12th January 2021

Planning (Listed Buildings and Conservation Areas) Act 1990 (as amended)

Application No: AB/125/20/L
Site Address: 19 Maltravers Street Arundel BN18 9AP
Description of works: Listed building consent for a single storey rear extension and alteration to existing kitchen roof.

19 Maltravers Street, Floorplan

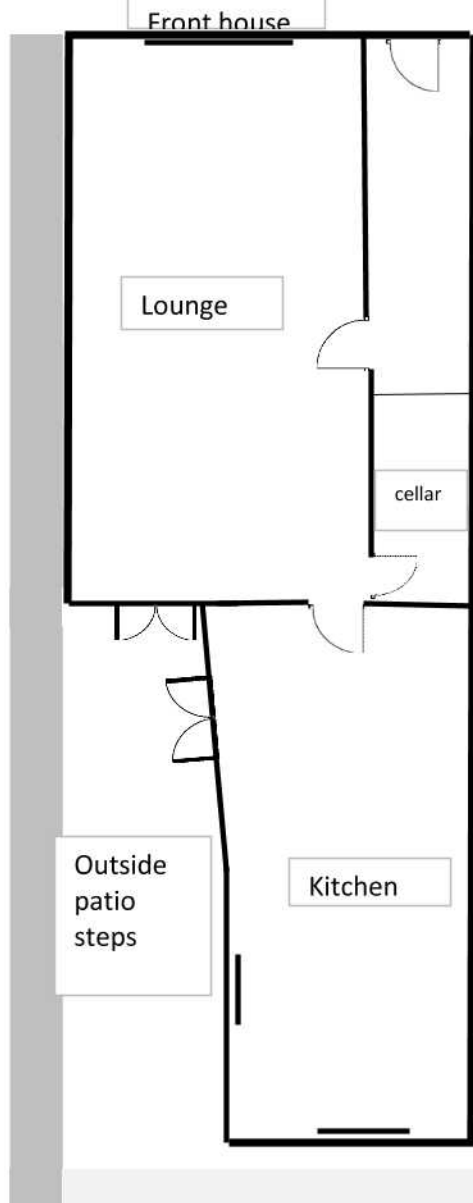
The Committee objected to the Application due to the lack of information on the finishes, materials and detailing.
